RE: SSD 7603; Nos. 24-28 John Street and Nos. 4, 6, 8, 10, 12, 14, 16, 18, 20, 22, 24, 26 and 28 Board Street, Nos. 3, 5, 7, 11, 13, 15 and 17 Ann Street, Lidcombe 2141 NSW

I object to part of the abovementioned proposal, namely the above-ground multistorey carpark that will be constructed on Board and Ann Street. I have not included any objection to the proposed hotel in this submission. Internet hyperlinks have been included for your convenience.

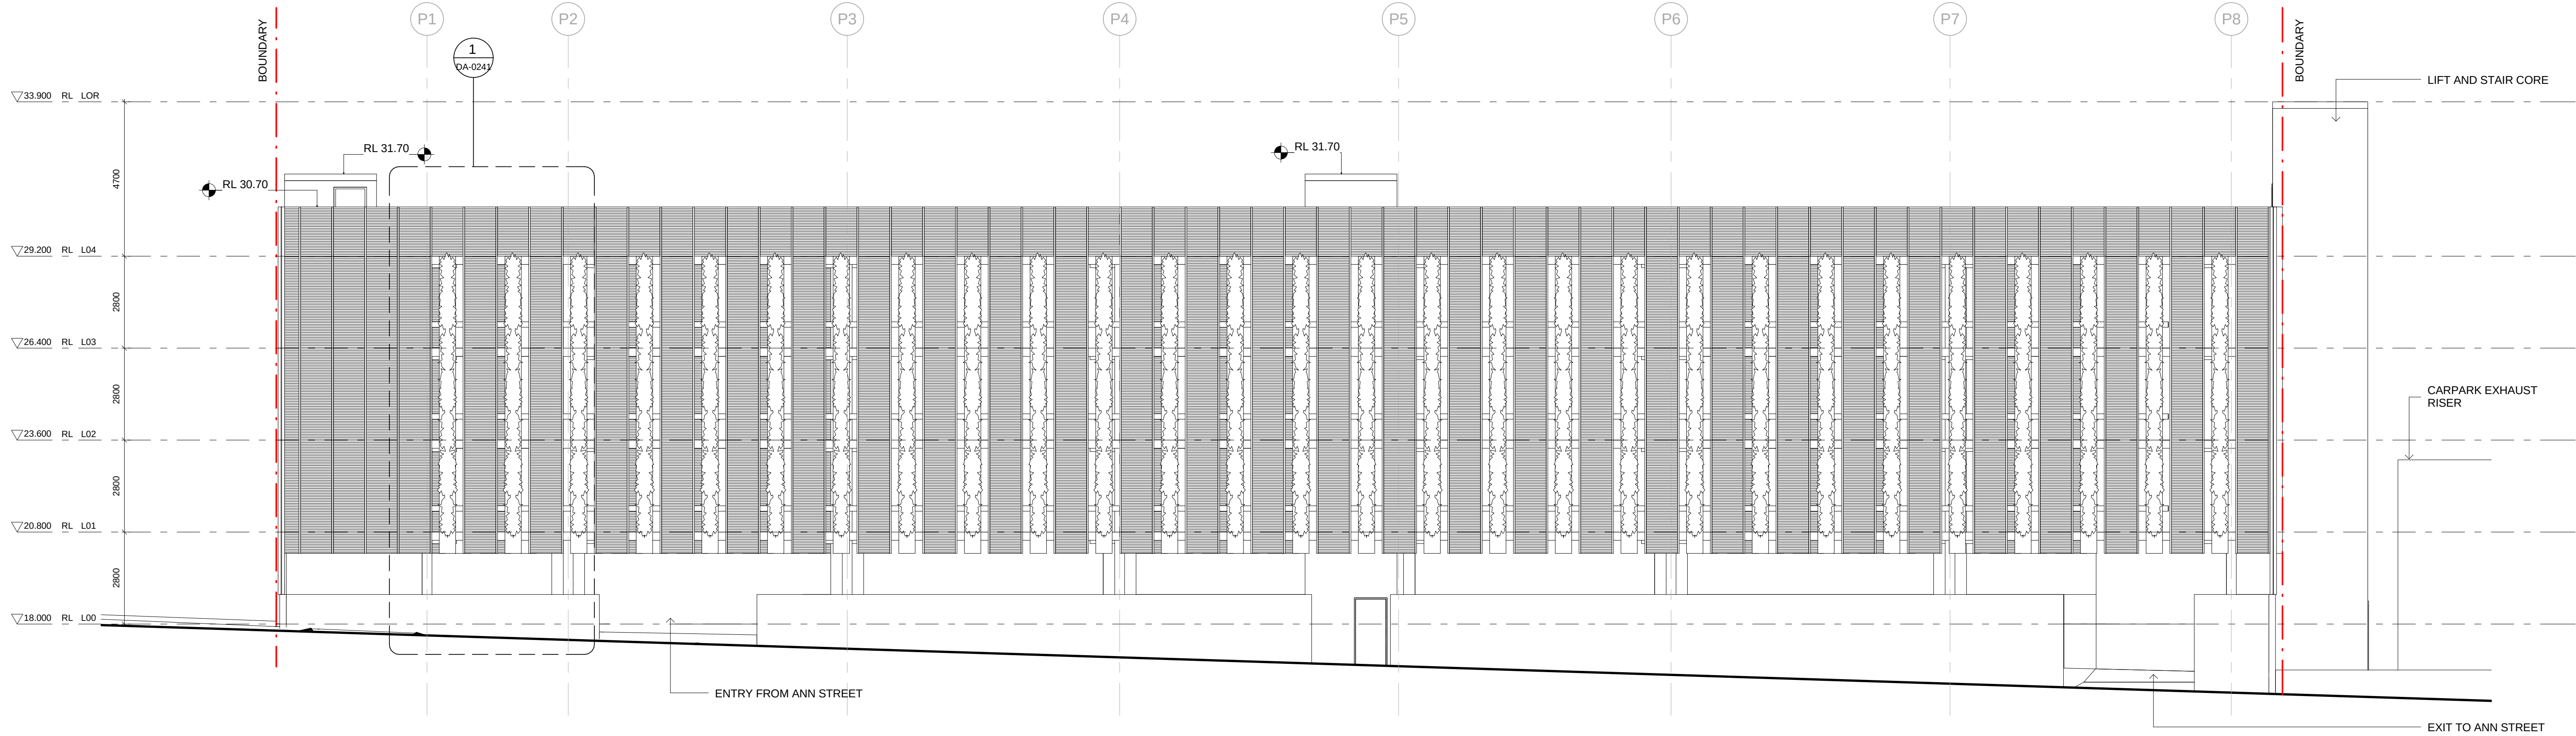
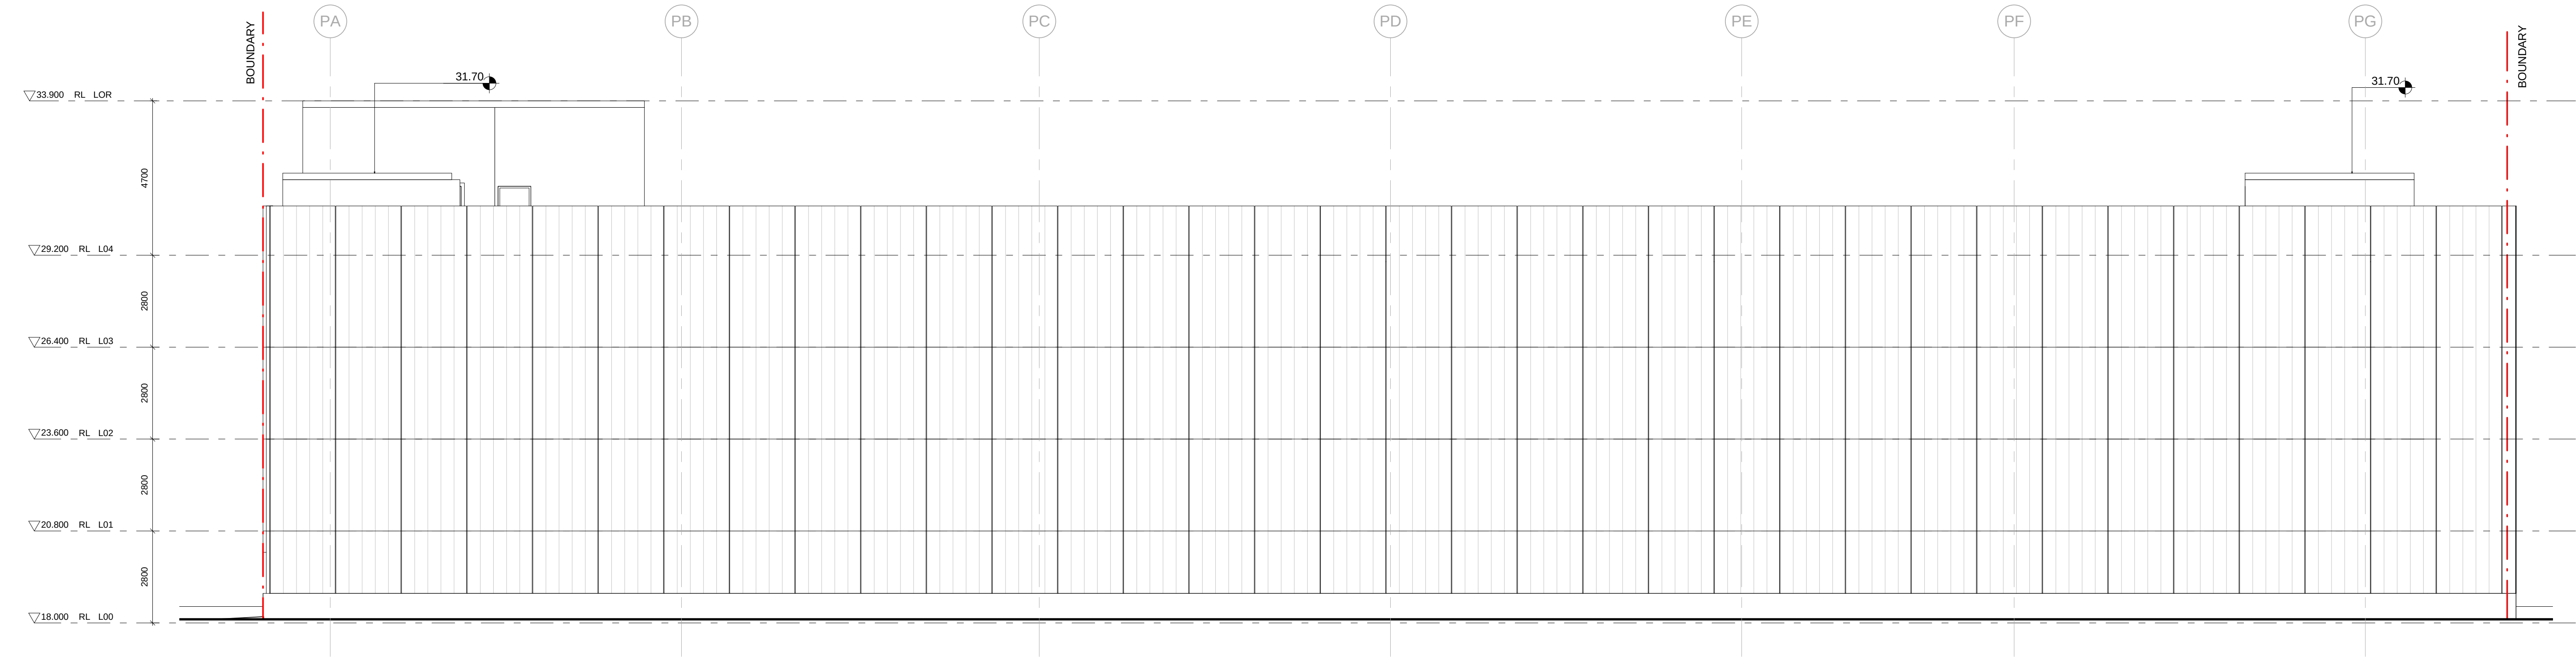
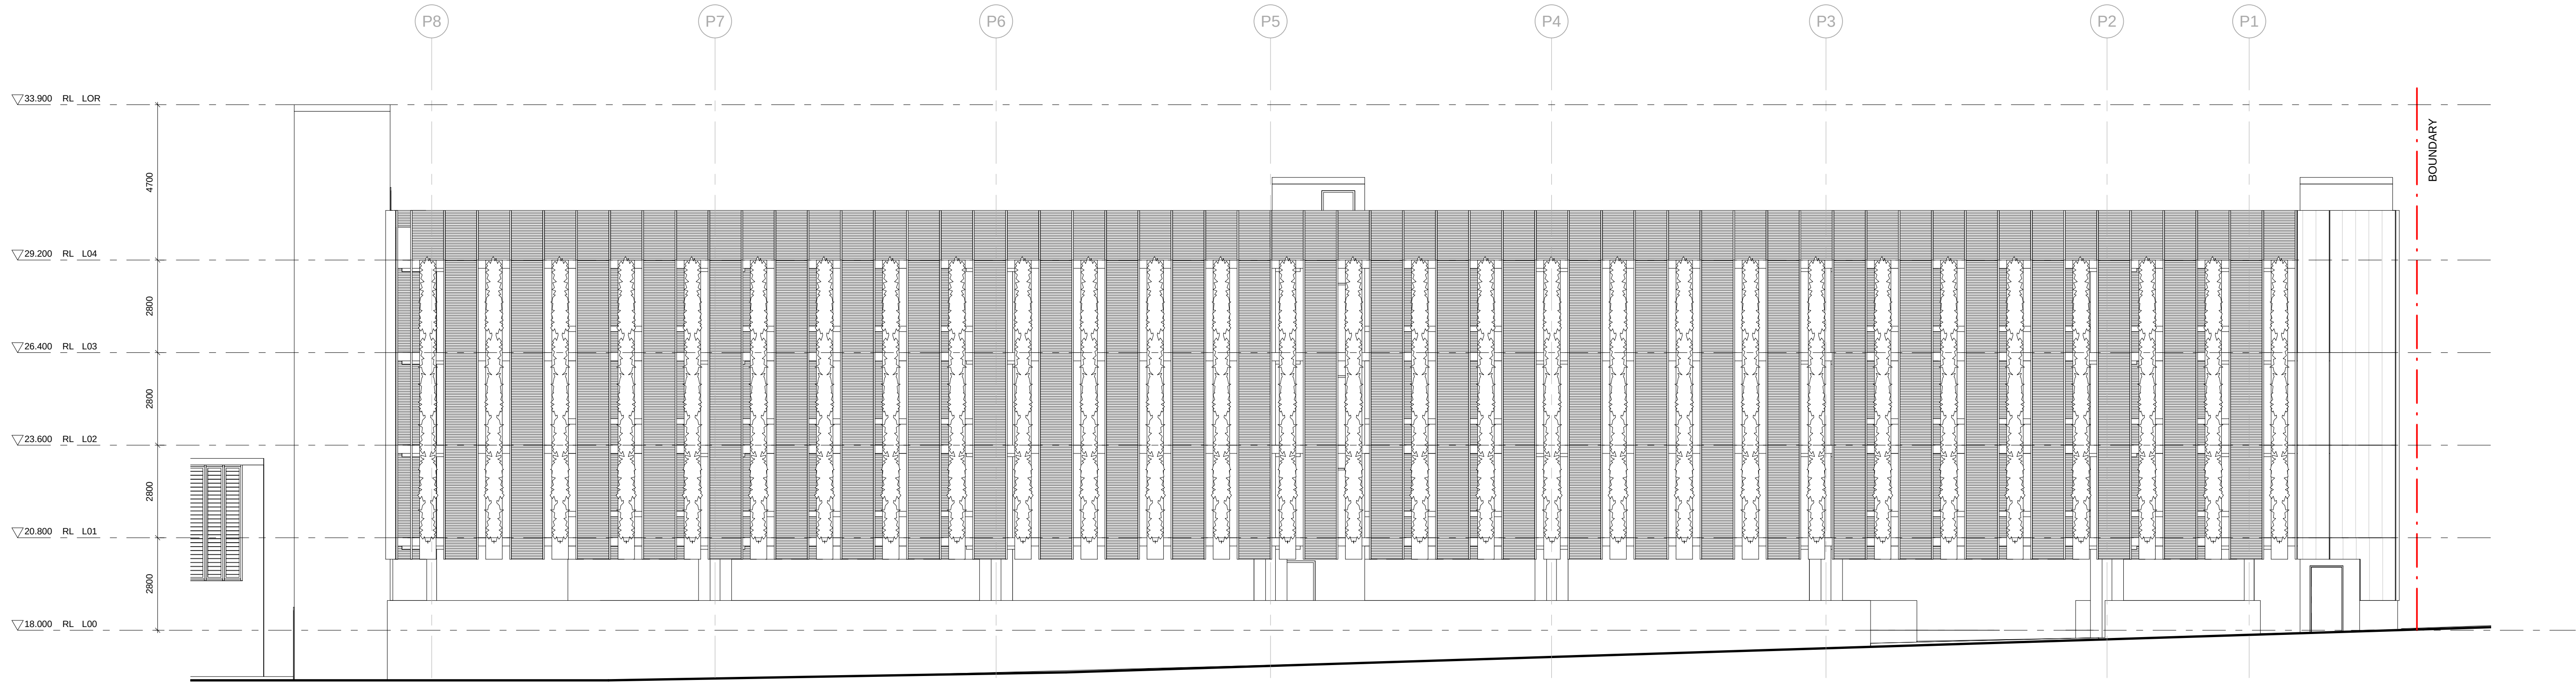
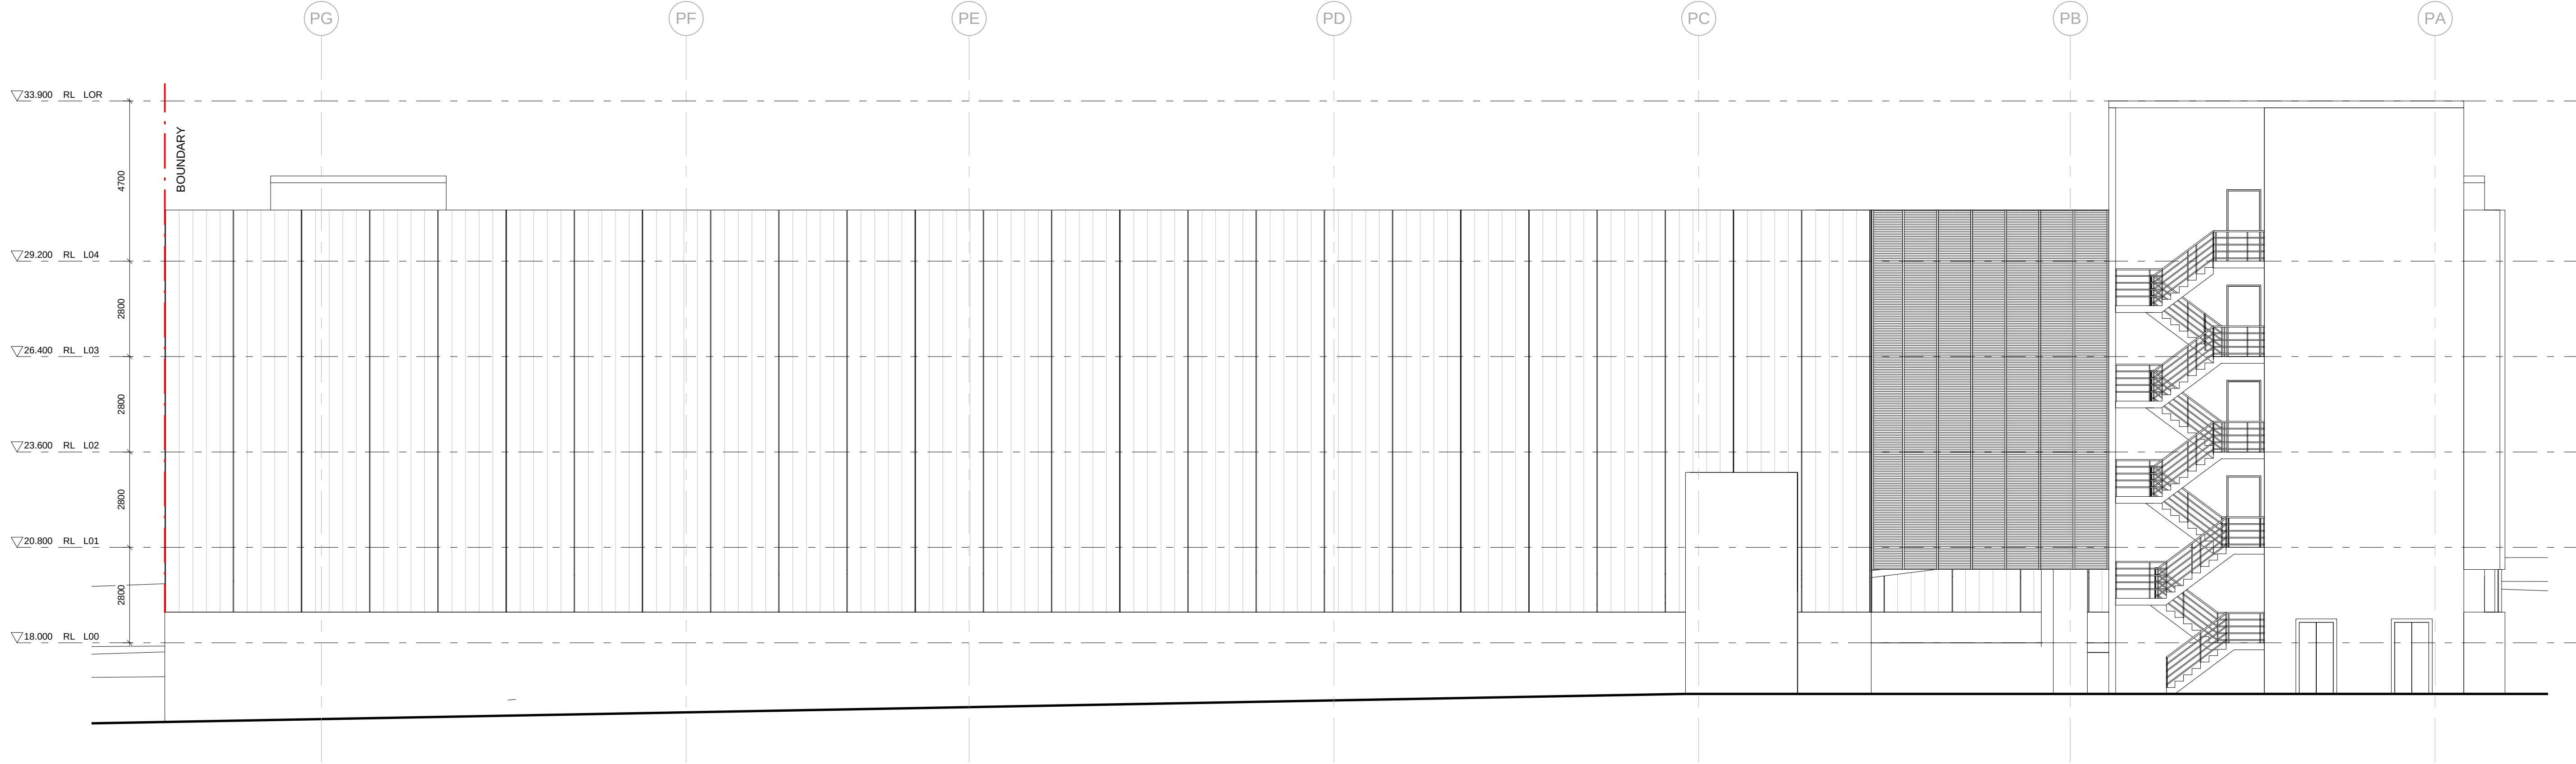
C 2 Residential Interface - the proposed carpark will be built much too close to my western boundary. My property would then be closely flanked on both my western and eastern boundaries by multistorey developments.

- I 3** Instead of the proposed boundary wall being built much higher than my single storey dwelling, build the boundary wall at or below the level of the *base* of the west-facing windows on my property.

- I 4** Ensure that the roof of the first storey of the carpark is no higher than the level of our ceiling of the west-facing rooms on my property.

- I 1** Instead of building so close to the boundary, setback the proposed multilevel carpark **at least 3 metres** from our common boundary.
- I 2** Instead of the current design with no stepping down, change the design of the carpark such that there is a **step-down**, with the higher storeys being closer to Olympic Drive than those closer to my property. In Figure 1, I have shown a situation where I would increase my solar access. The eastern wall of the first storey could be spaced at least 10 – 12 metres from the eastern wall of the second storey. The eastern wall of the second storey could be spaced at least 10 – 12 metres from the eastern wall of the remainder of the storeys.
